Our Ref: 20/01196/FUL  
Your Ref:

LOCATION: 51 Cedar Grove, Portsmouth, PO3 6HH, ,

PROPOSAL: Construction of single storey rear extension and roof conversion  
**(20/01196/FUL)**

PROPOSED FRONT ELEVATION
SCALE: 1:100(BA1)

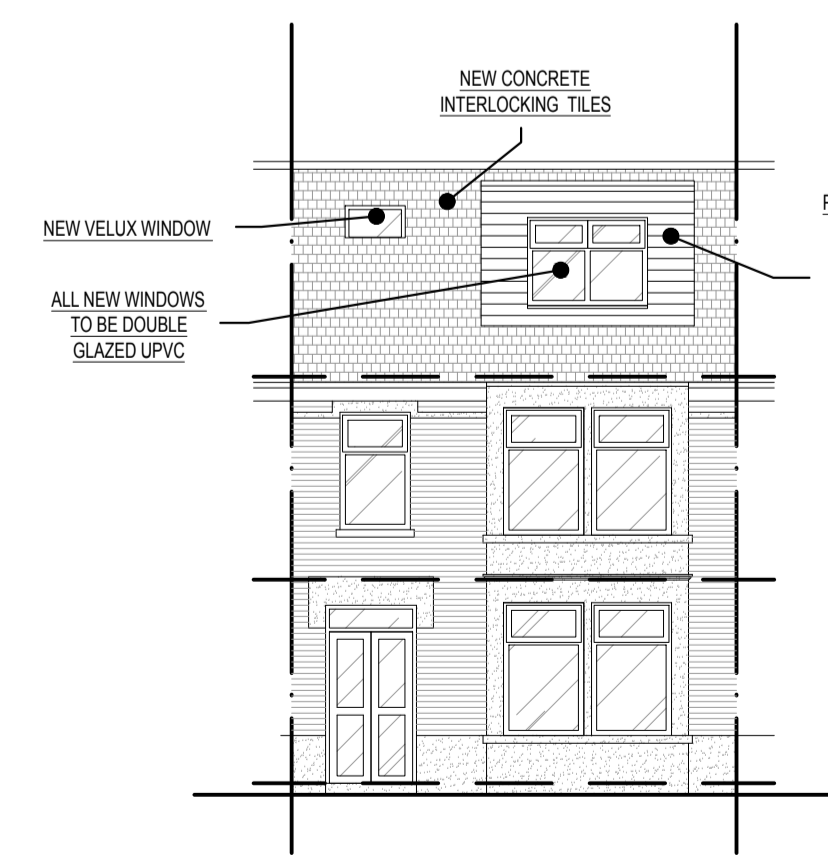
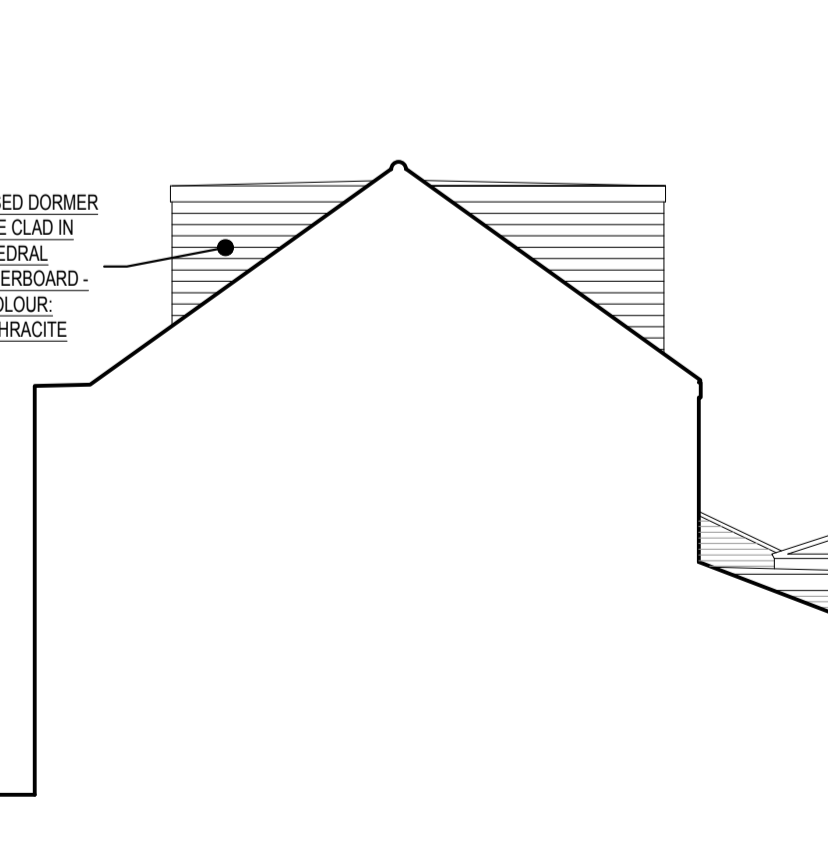
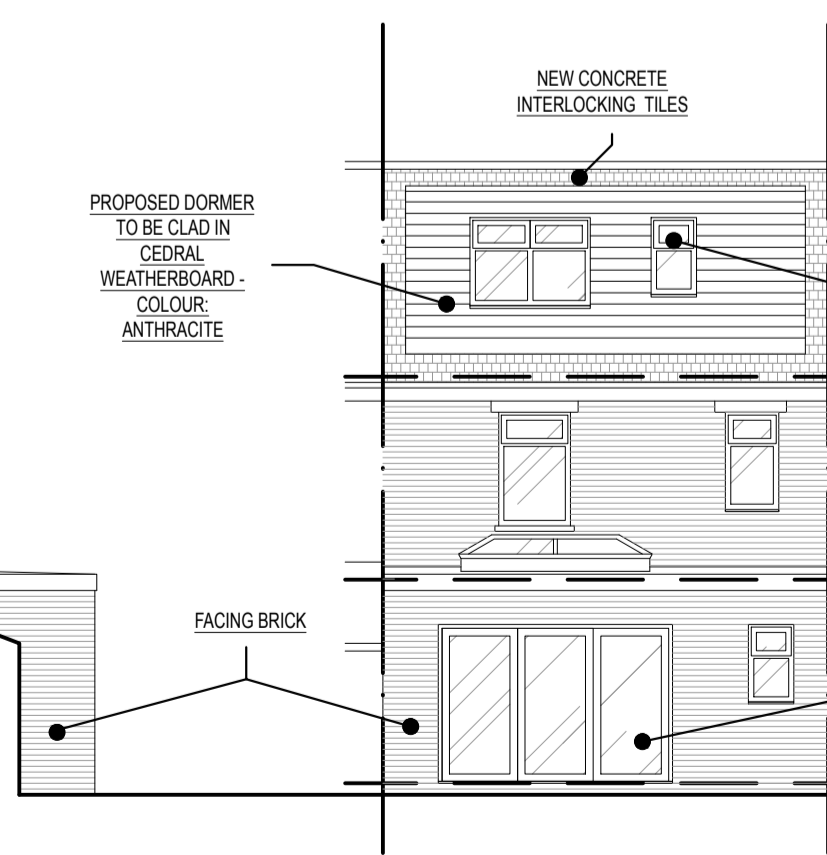
1) The naming of the proposed elevations are required to be proposed. Please review.
